Ribble Valley Borough Council  
Housing & Development Control

Application no: **3/2022/1055**

Address: **59 Mellor Brow Mellor BB2 7EX**

Proposal: **Proposed front porch and front dormers. Two storey rear extension and material changes.**

Existing Ground Floor Layout

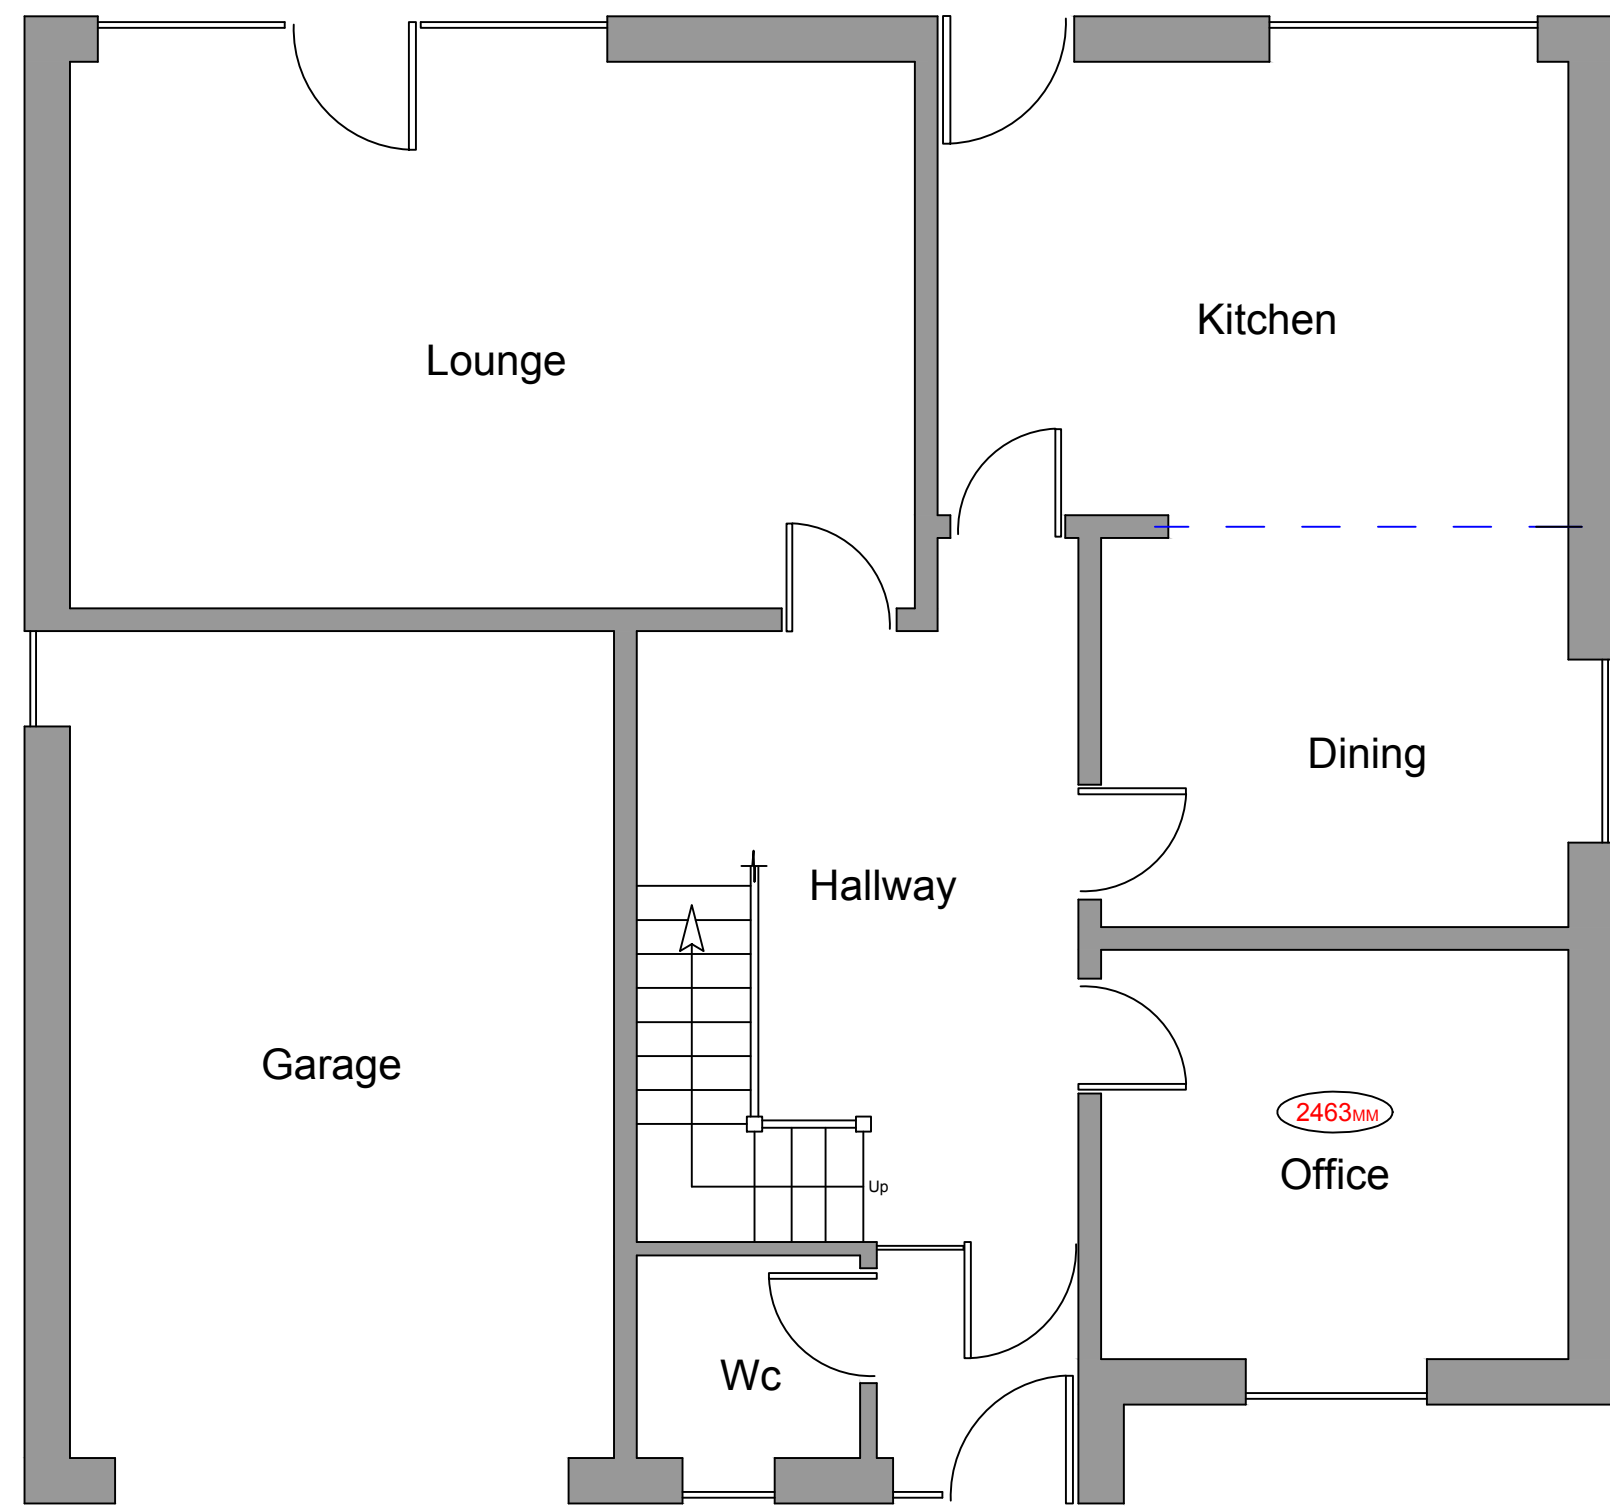
The LHA advise that, due to the lack of space to lengthen the existing driveway that the internal garage is retained as part of the application. This is because as shown on, PCE drawing number PCE-Parkin-September-22-Existing, the dimensions of the existing garage complies with the LHAs guidance when providing a car parking space. Therefore, for the LHA to support the application the internal garage should remain or be extended to provide two car parking spaces. The dimensions for a double garage when providing two spaces is 6m x 6m.

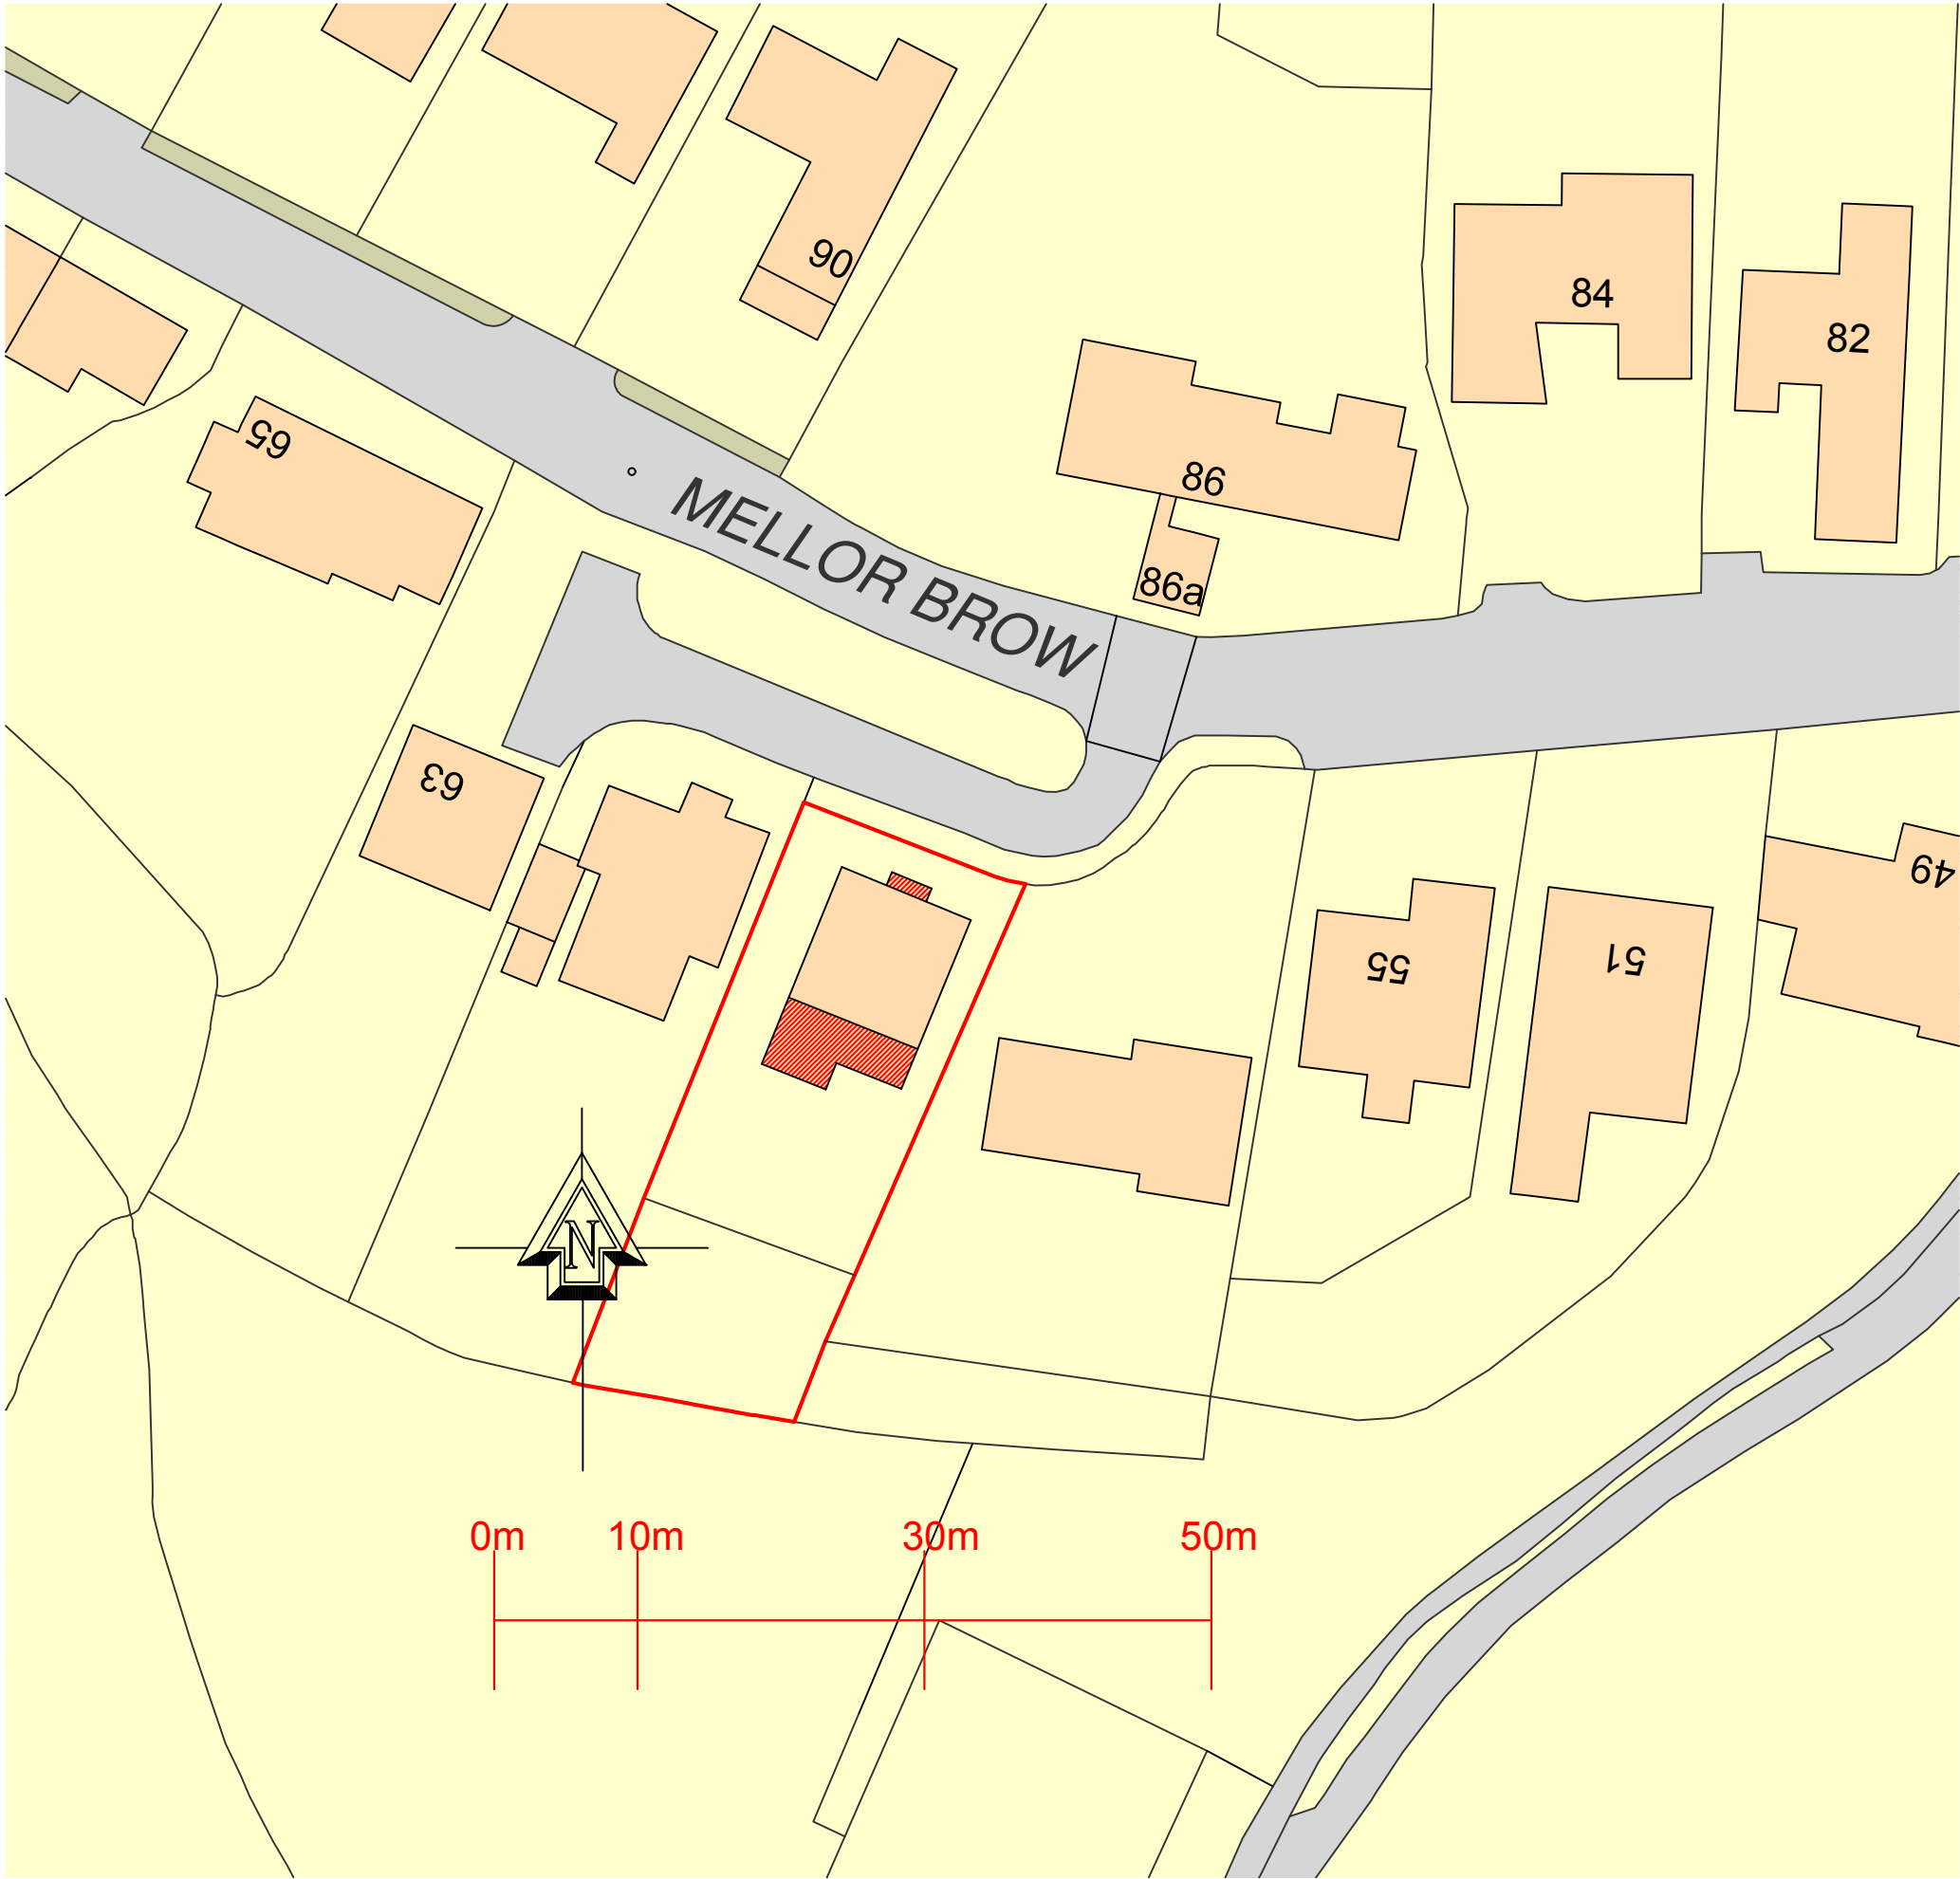
For the site to comply with the LHAs parking guidance as defined in the Joint Lancashire Structure Plan, the LHA require a minimum of 3 car parking spaces to be provided at the site. Therefore, the LHA require a parking plan to be submitted showing that the site can comply with the LHAs guidance.

The LHA makes the Applicant aware that the LHA will not accept any on-street parking from occurring in this location. This is because the LHA are concerned that should the LHA allow for the facilitation of on-street parking, that parked vehicles outside of the dwelling could obstruct the use of the turning head for emergency vehicles located at the end of the cul-de-sac approximately 25m from the dwelling, which is unacceptable.

Furthermore, the LHA are aware by reviewing the computer mapping software, Google Streetview with images of the dwelling dating back to March 2009, that the two car parking spaces located on the existing driveway outside of the garage are unlikely to have the required dimensions to be considered as a car parking space. This is because the LHA require the depth of a driveway to be a minimum of 4.8m to prevent any overlapping of a parked vehicle onto a footway. However, as seen in the images, the two parked cars overlap the footway which is unacceptable.

The LHA are aware that this is a pre-existing situation at the site and while the LHA do not condone a parked vehicle overlapping the footway, the LHA are unable to prevent this from occurring but will insist that a minimum of one car parking space should comply with the LHAs parking guidance.
